El Paso County Review Comments

Geometric Design Plans Submitted by Kimley-Horn (dated 09/16/2022)

SB-EB LEFT TURN

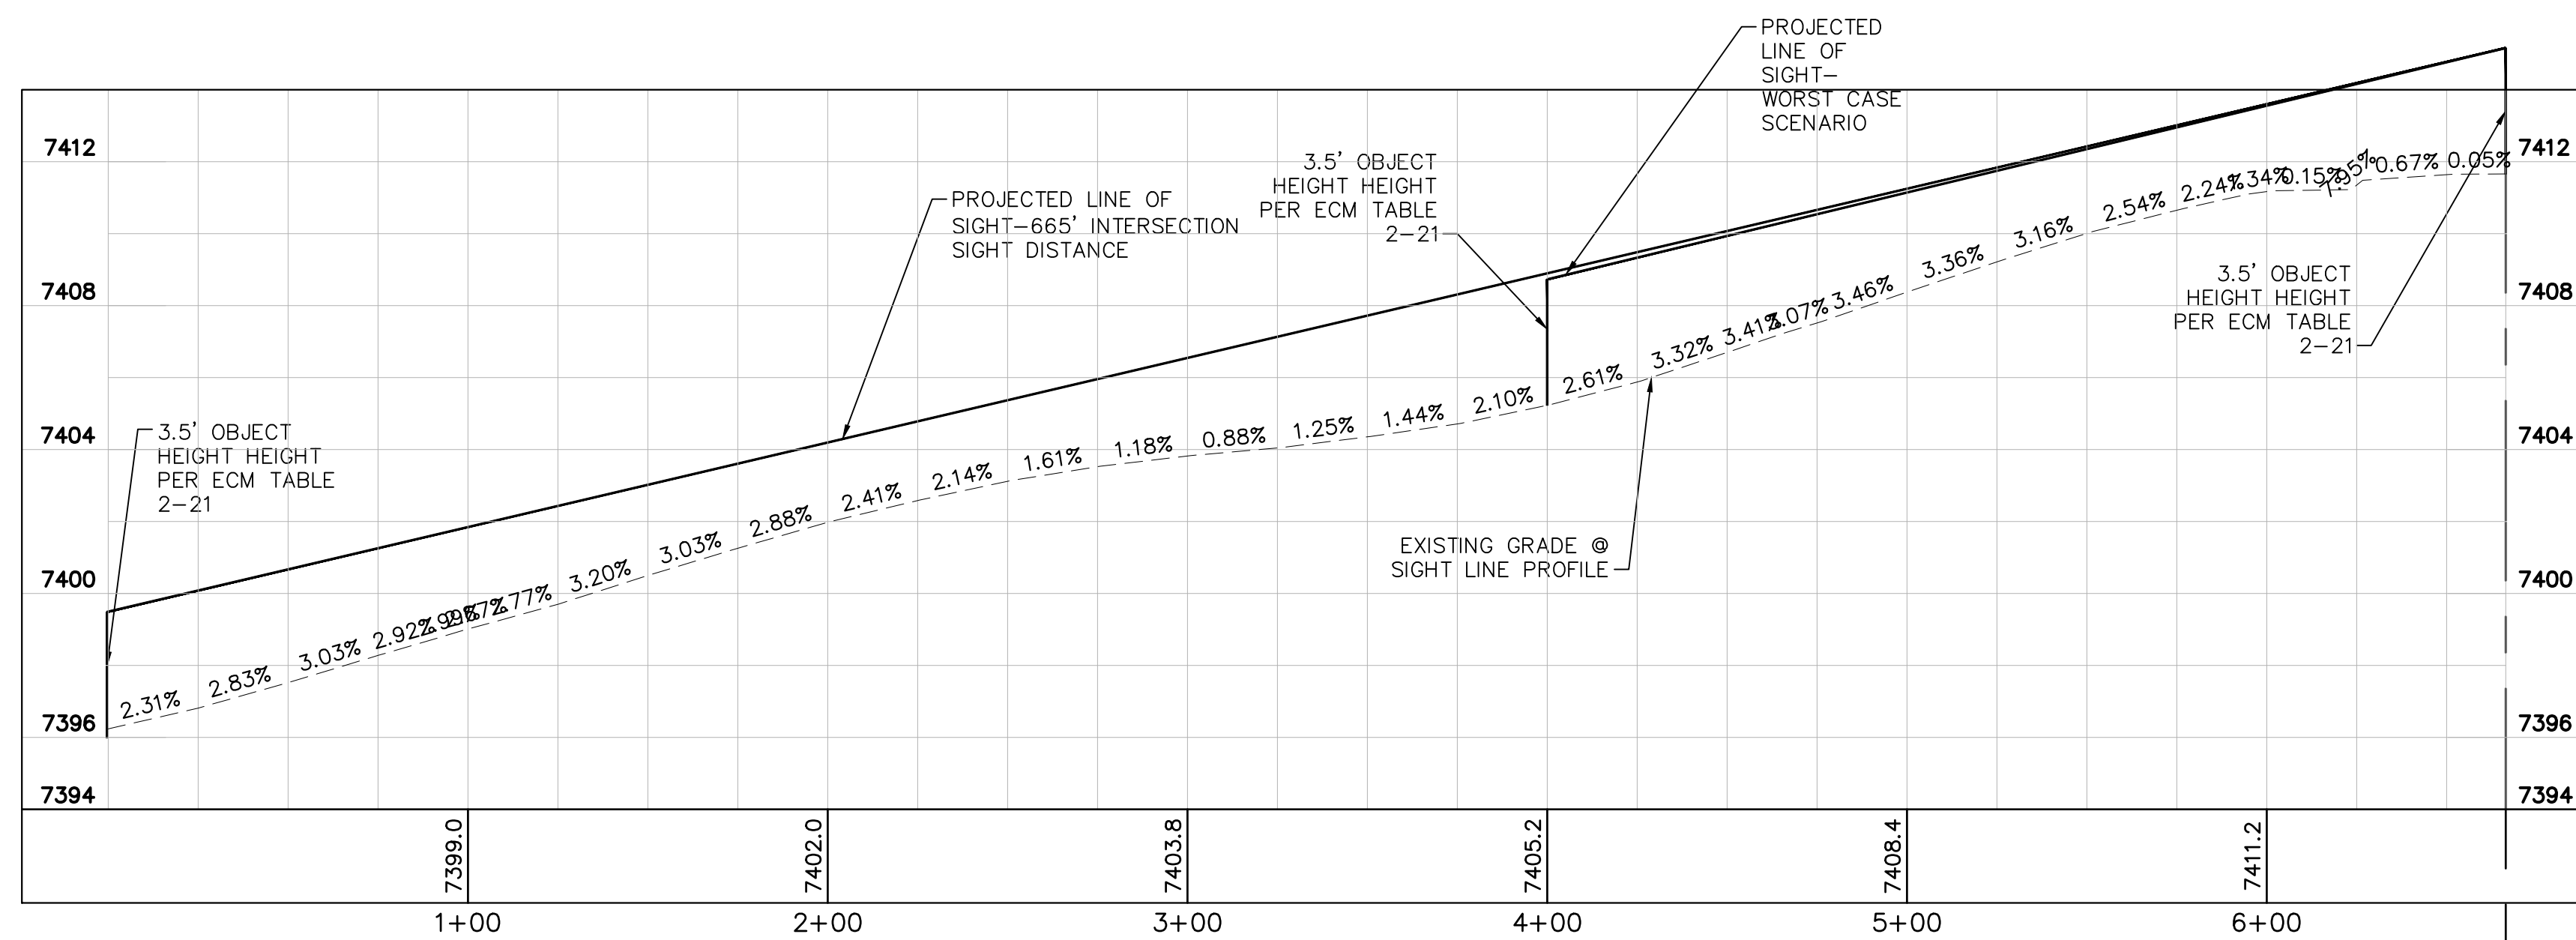
1. ALL SHEETS
 - a. Sight Lines/Profiles need to be shown for all movements to and from Winsome/Hodgen intersection, including the design truck vehicle or WB-50.

- b. Stopping sight distance (SSD) needs to be met for all vehicles to and from intersection.
 - i. Since profile of Hodgen Road is not proposed to be modified, possible mitigation for such may include deceleration/acceleration lane for traffic entering and exiting Winsome Way as appropriate to meet engineering criteria.

K:\COS_Civil\196106001_Winsome Filing No. 3\CADD\PlanSheets\Winsome 1 Roadway\196106002_Winsome Way Realignment-WB-50.dwg

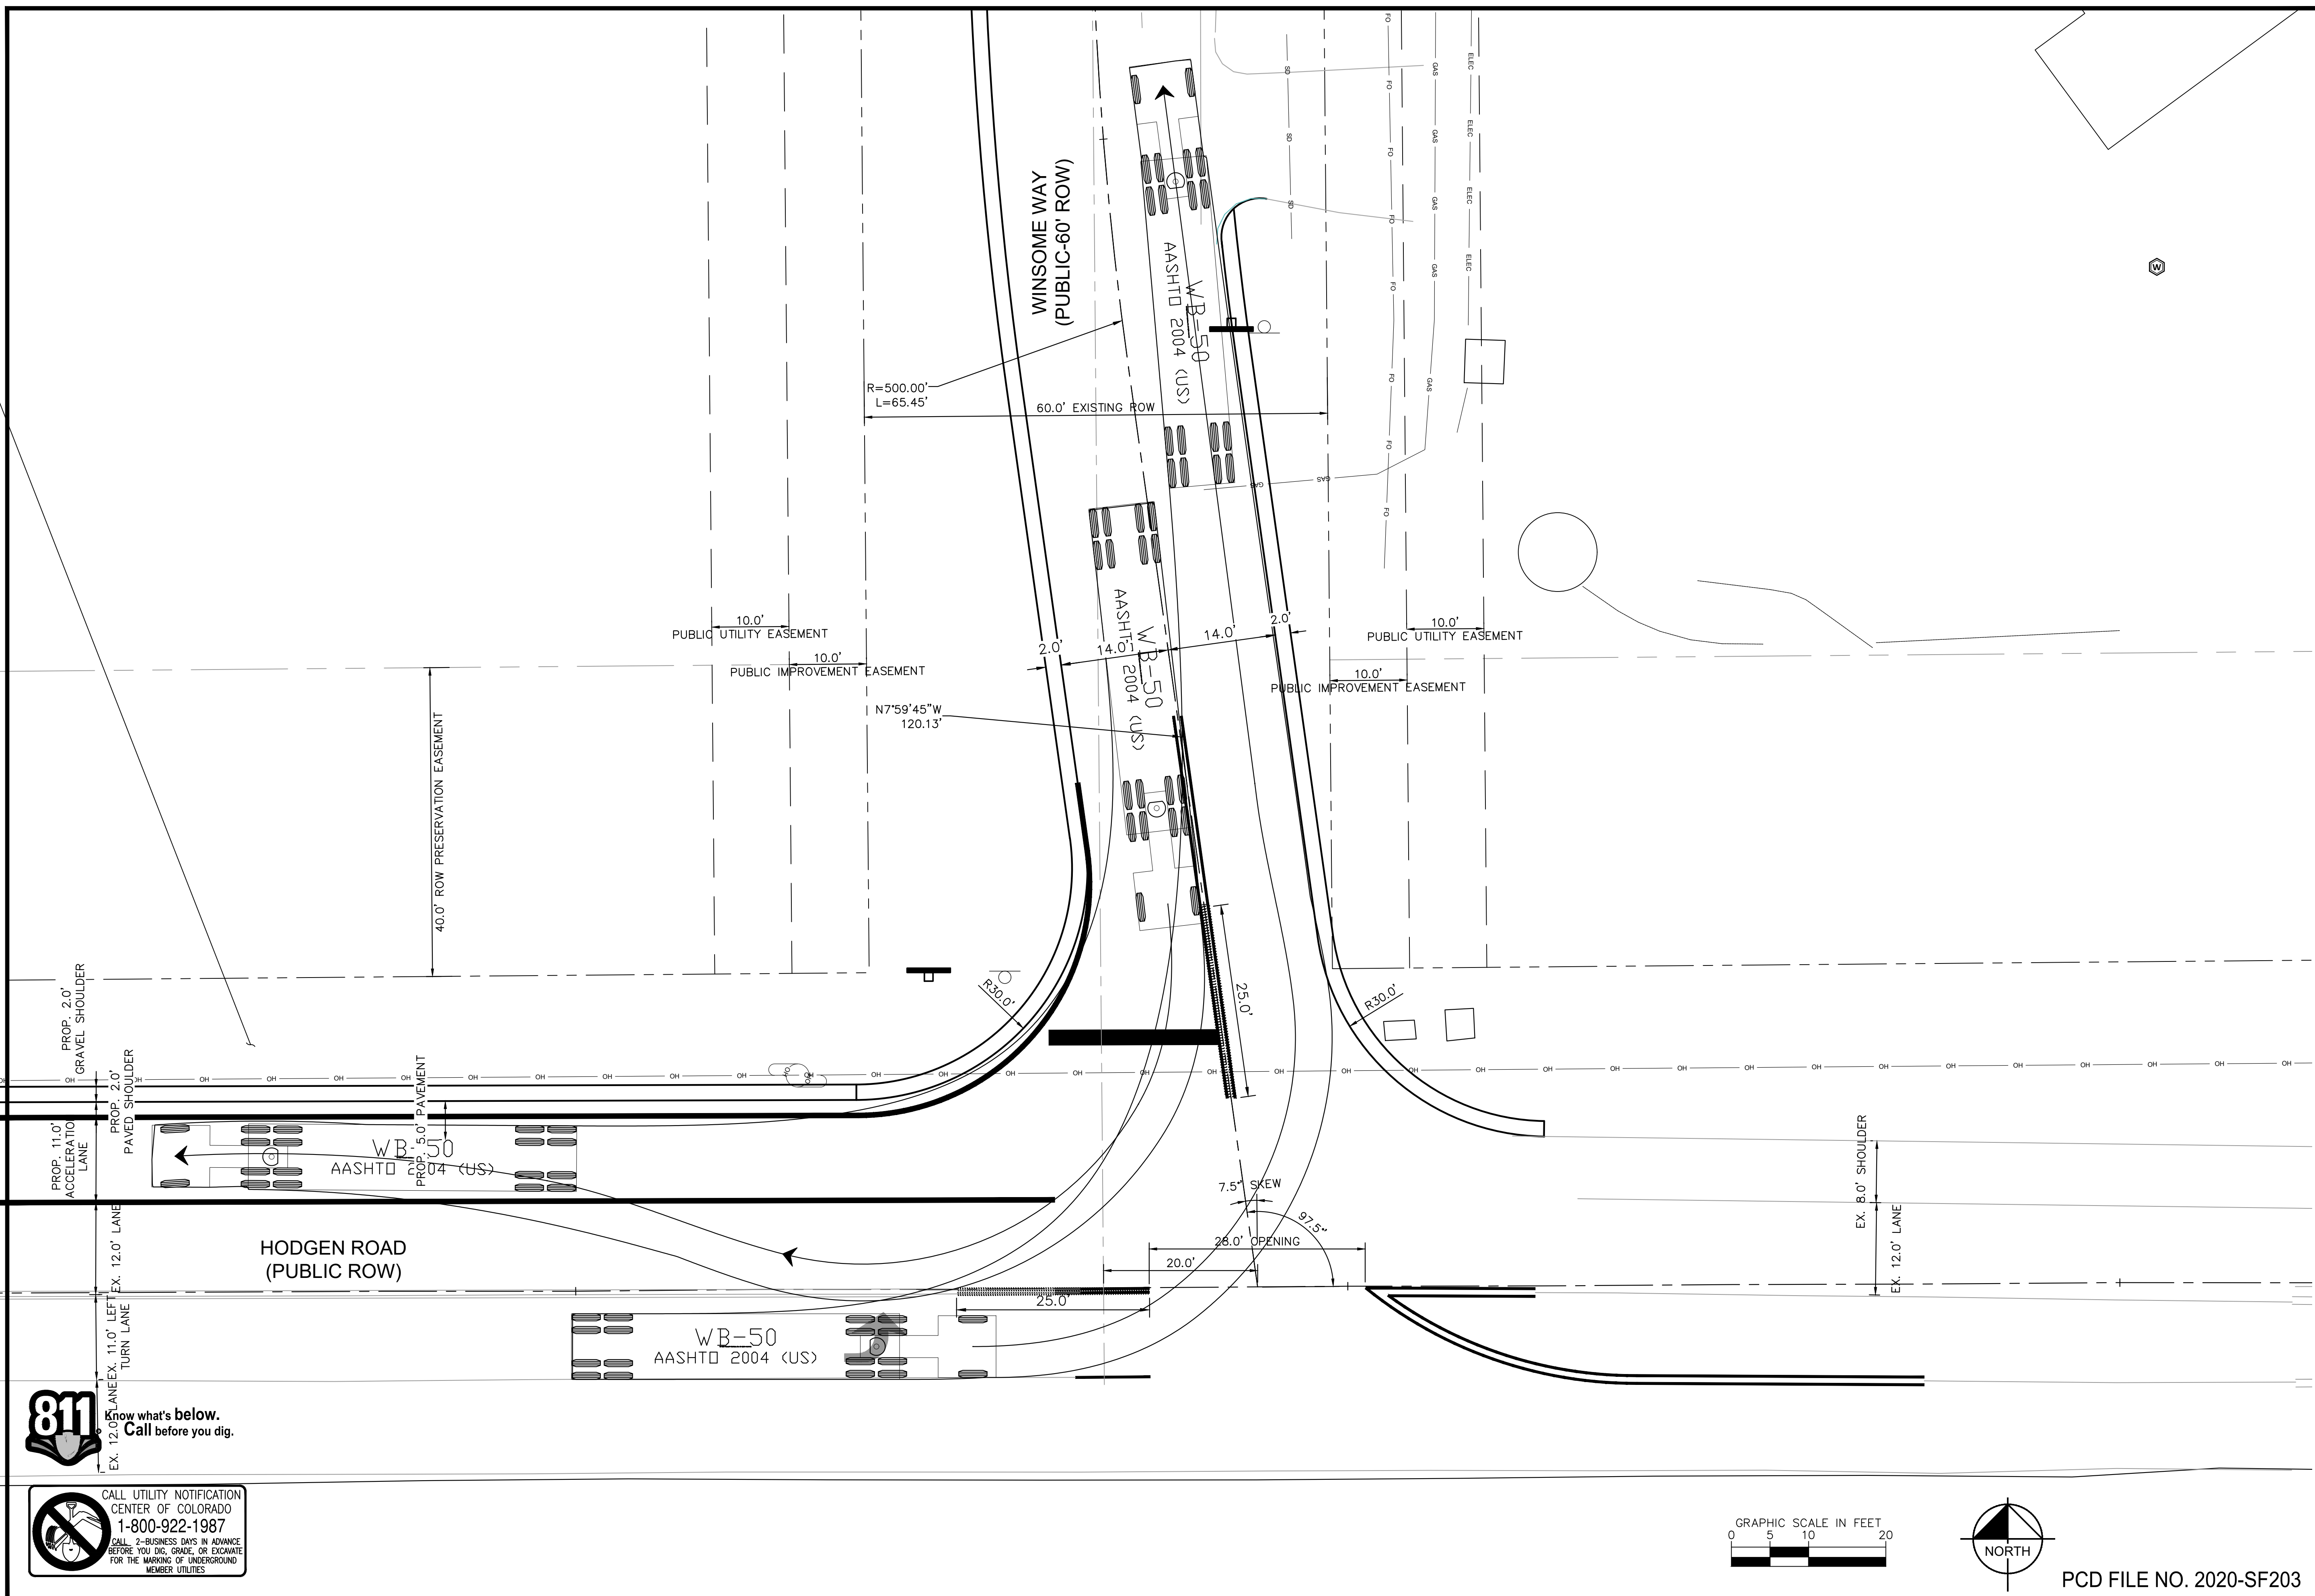
- c. Delete "proposed dog tracks". This is conflicting with median opening clear zone.
3. Sheet 3 of pdf
 - a. WB-50 is off-pavement in turning movement and not allowed per criteria (ECM 2.3.7.G.3). Adjust pavement width to accommodate.
